Rezoning Transportation Analysis

Petition Number: 2023-134

Date	Description
11-21-23	First Review (NK)
12-20-23	Second Review (NK)
1-24-24	Third Review (NK)

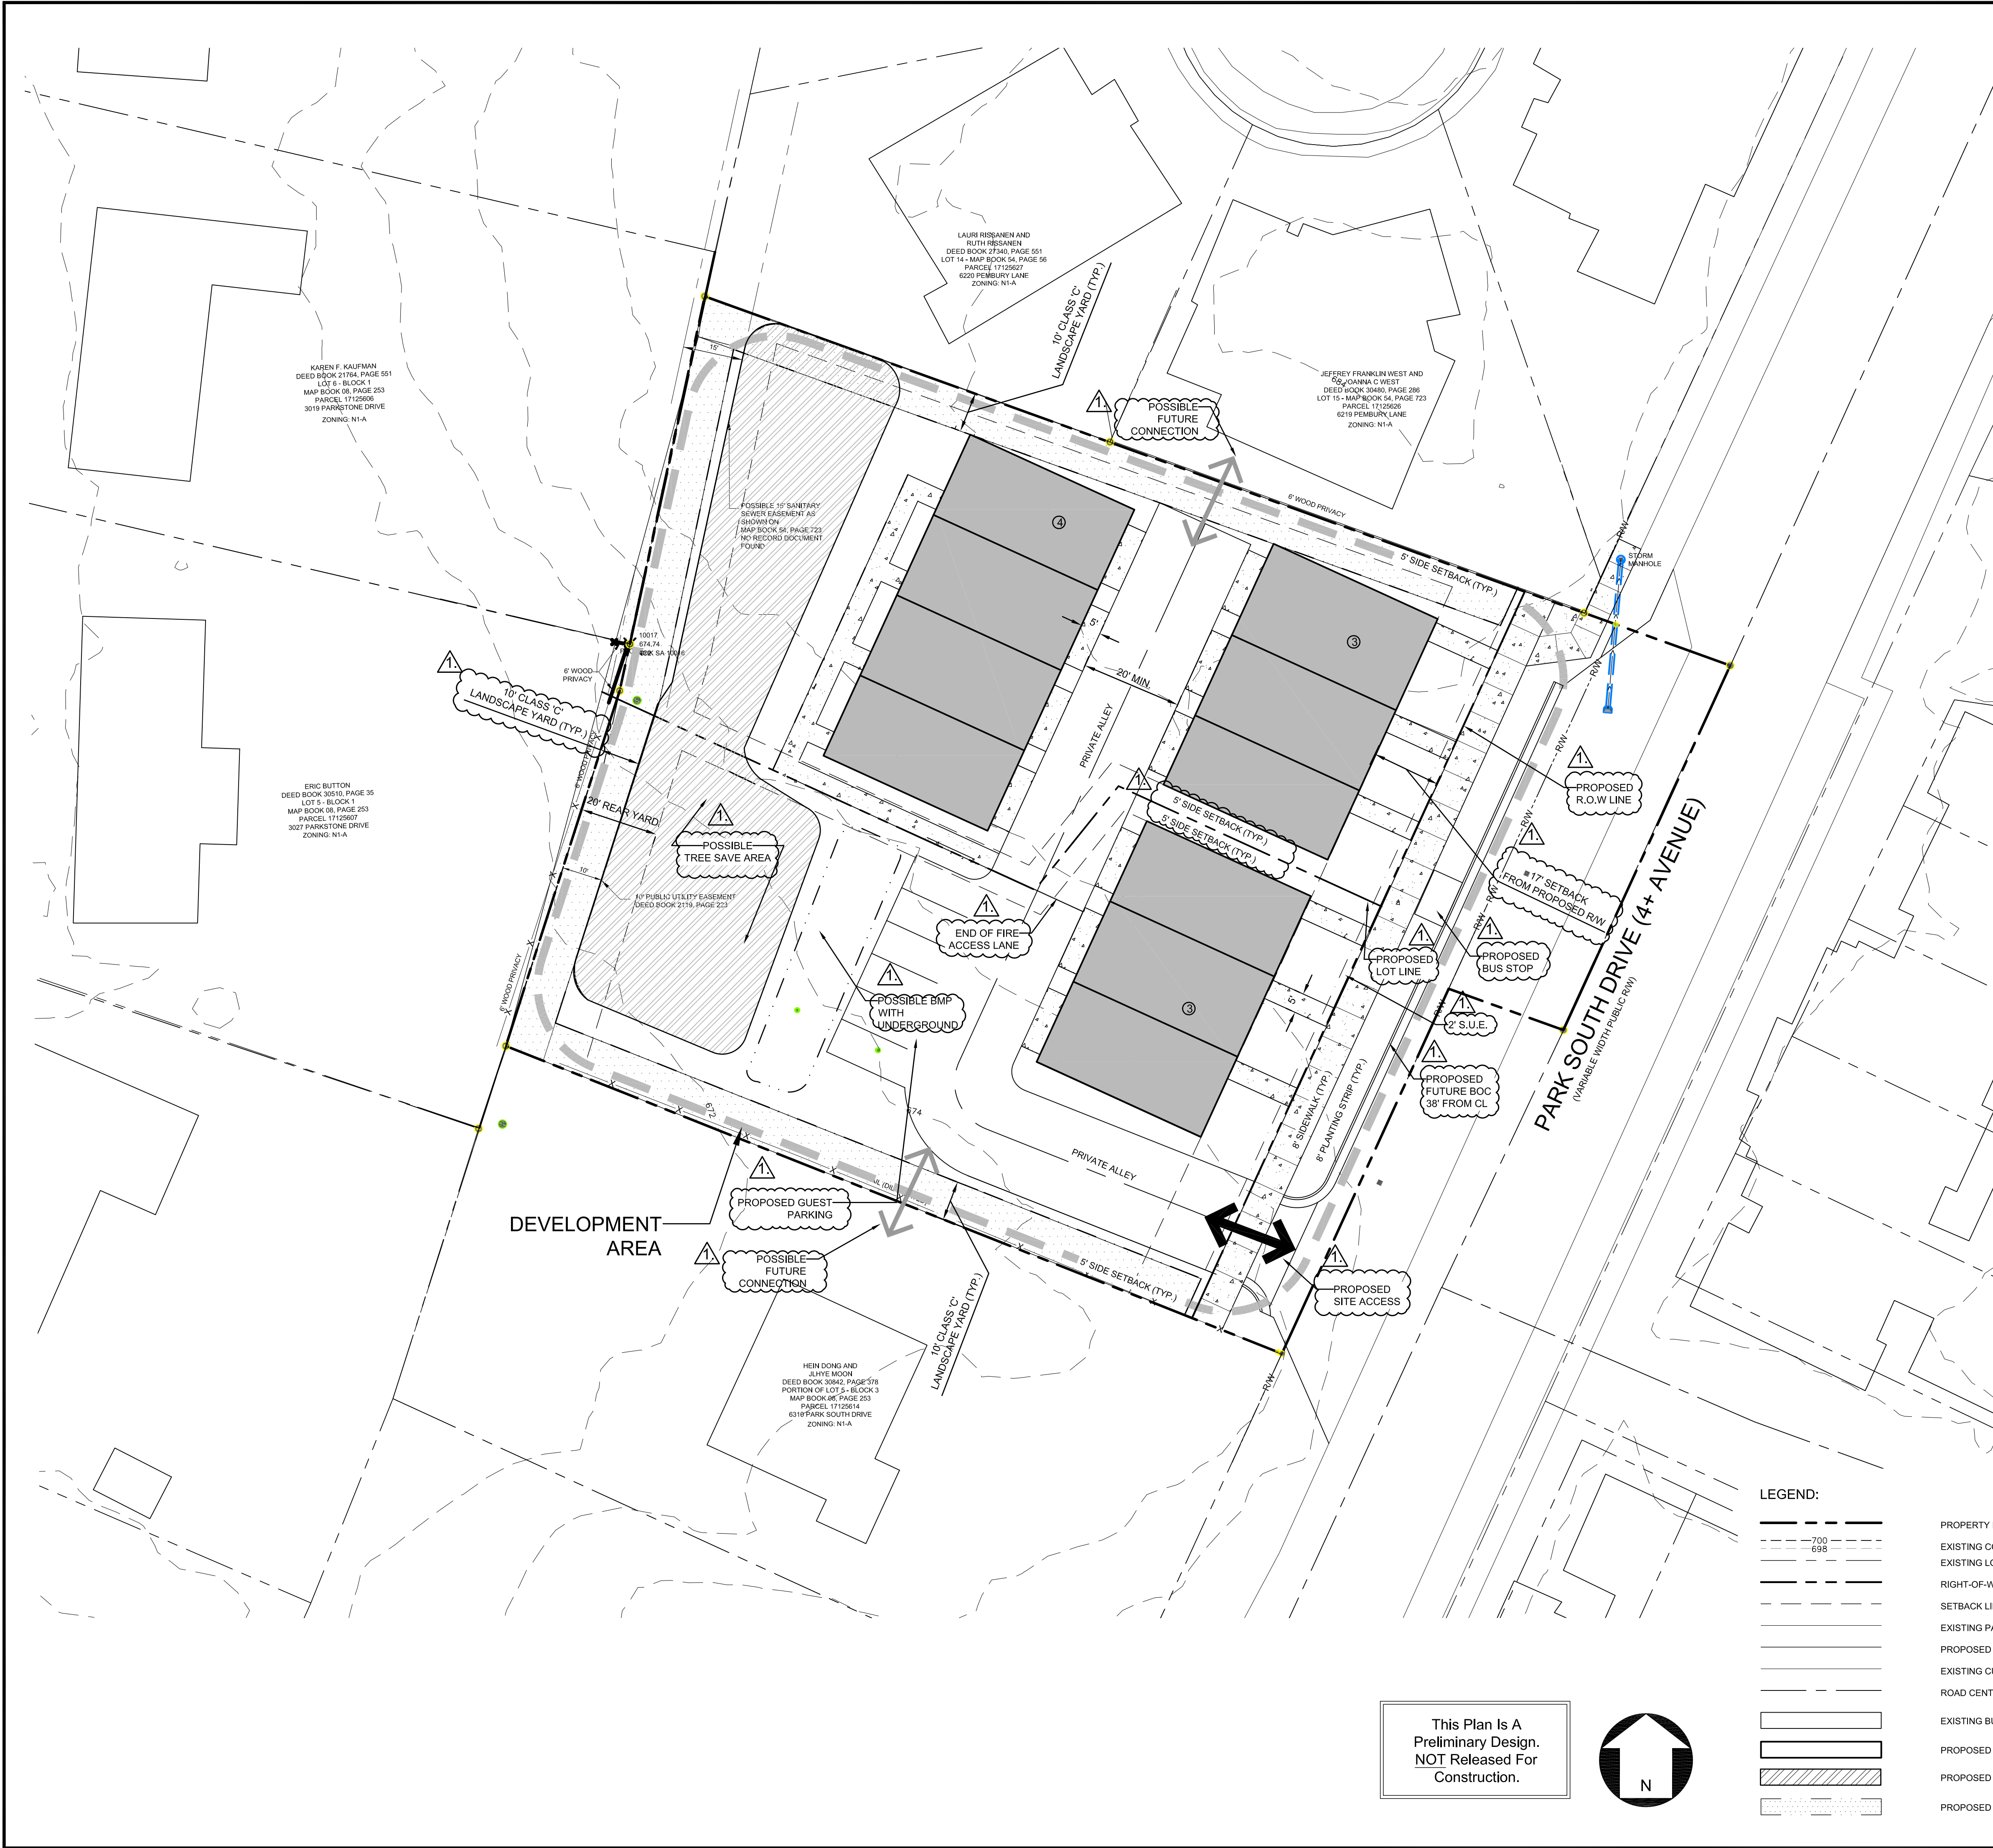
1. ~~Curblines:~~

~~**Park South Drive:** Location of future curb and gutter to be moved 38' from centerline to back of curb.~~

~~Cross Section: 4+ Avenue, Buffered/Separated Bike Lanes according to Streets Map~~

~~Label and dimension the curb and gutter from the centerline for each road on the site plan.~~

~~3. Revise site plan and conditional note(s) to commit to dedicate 56' right-of-way from the road centerline. The site plan shall label and dimension the right-of-way from the road centerline.~~

~~4. Revise site plan and conditional note(s) to commit to construct bicycle facilities by locating the curb and gutter 38' from the center line.~~

~~**Clarifying Comment 12/20/23:** Dimension for proposed BOC to CL needs to be shown on the plans as well as the buffered bike lane that is required per the Charlotte Street Map cross section.~~

~~5. Revise site plan and conditional note(s) to commit to aligning driveway with the driveway located on the opposite property~~

6. ~~Revise site to commit to a cross access stub connection to the southern abutting property per Article 31 of UDO. Add a conditional note committing to recording a cross-access easement to both the northern and southern properties.~~
